# DEVIATION REQUEST AND DECISION FORM

Project Name : The Sanctuary - PUD  
 Schedule No.(s) : 4200000402, 4200000450, & 4220403091  
 Legal Description : Exhibit A (see attached)

A deviation from the standards of or in Section **F, SD 2-75 Urban Cul-De-Sac Details** of the Engineering Criteria Manual (ECM) is requested.

CUCHARA WAY CUL-DE-SAC (ALL GRADES ARE TBC)

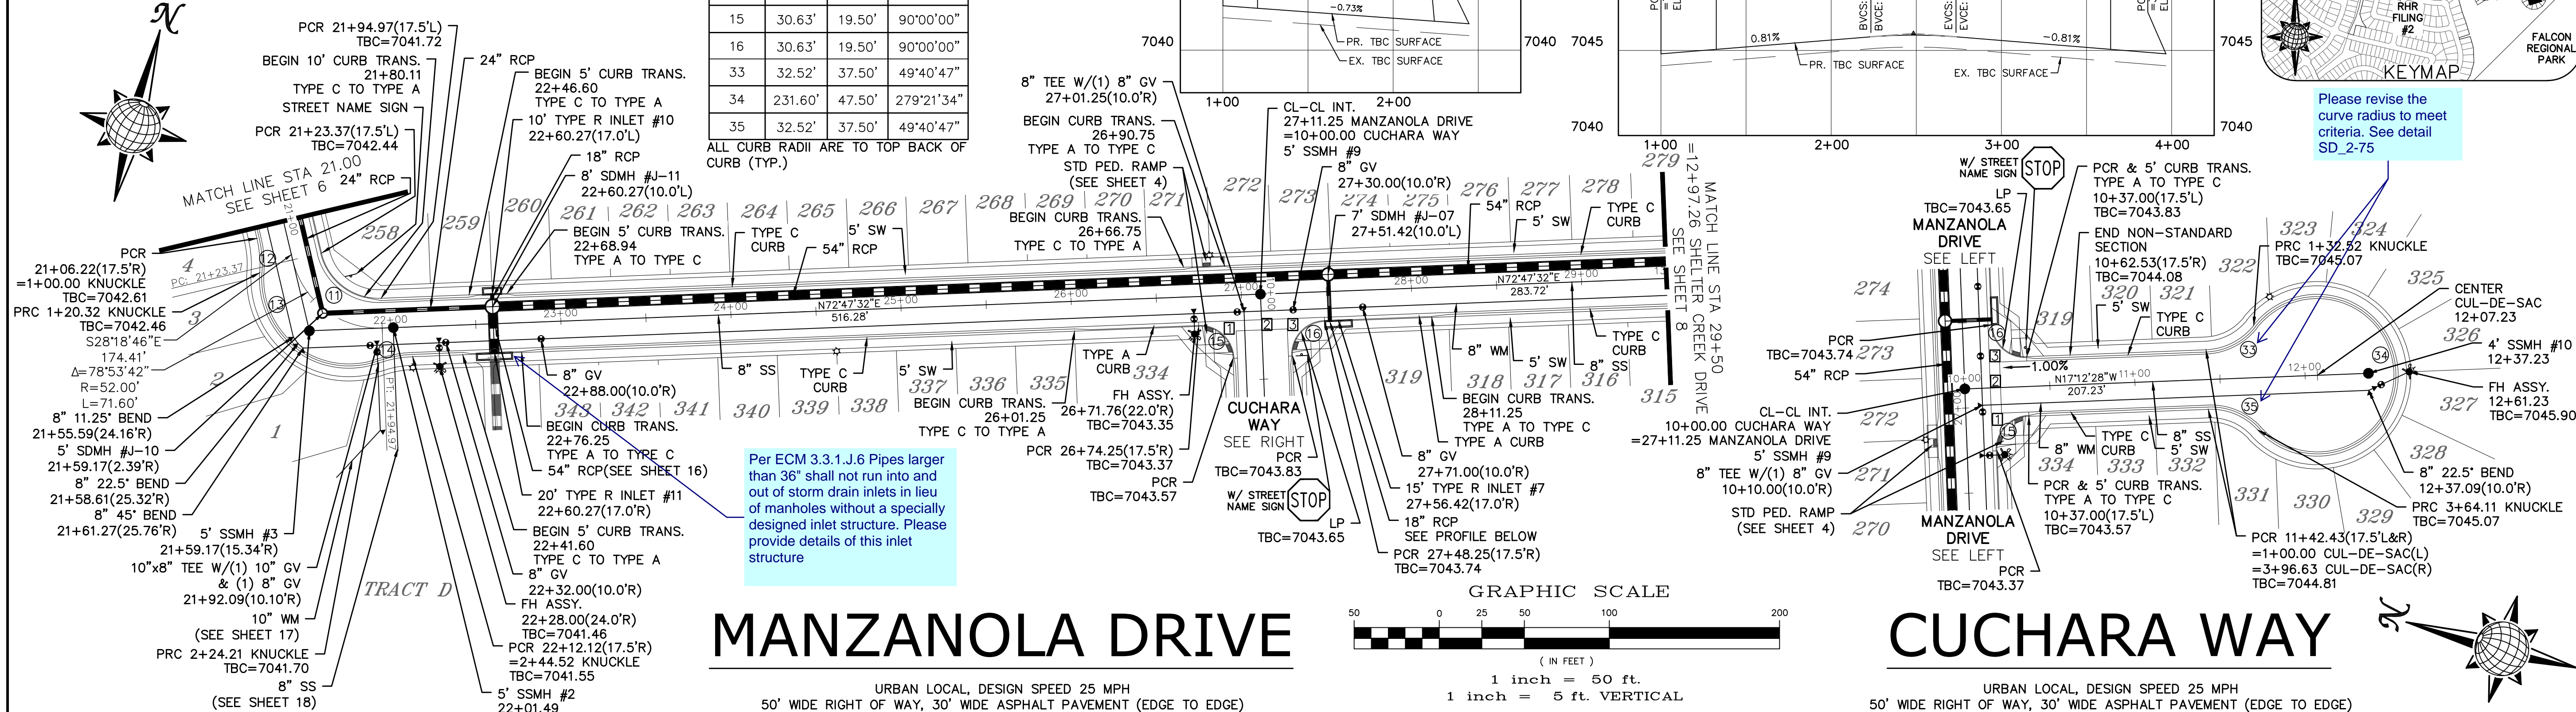
The proposed alternative will match the approved Meridian Ranch Deviation DEV134 (2013). See comparison of ECM detail SD\_2-75 as redlined Exhibit B (see attached).

The nature of DEV134 was to allow a detached sidewalk on the urban local roadway cross section that indicates an attached sidewalk. Part of the reasoning highlighted was the additional 10' of ROW provided in that proposed cross section. These roadways are 50' ROW with attached sidewalks.

We are not opposed to the proposal but believe that your reasoning/justification needs work.
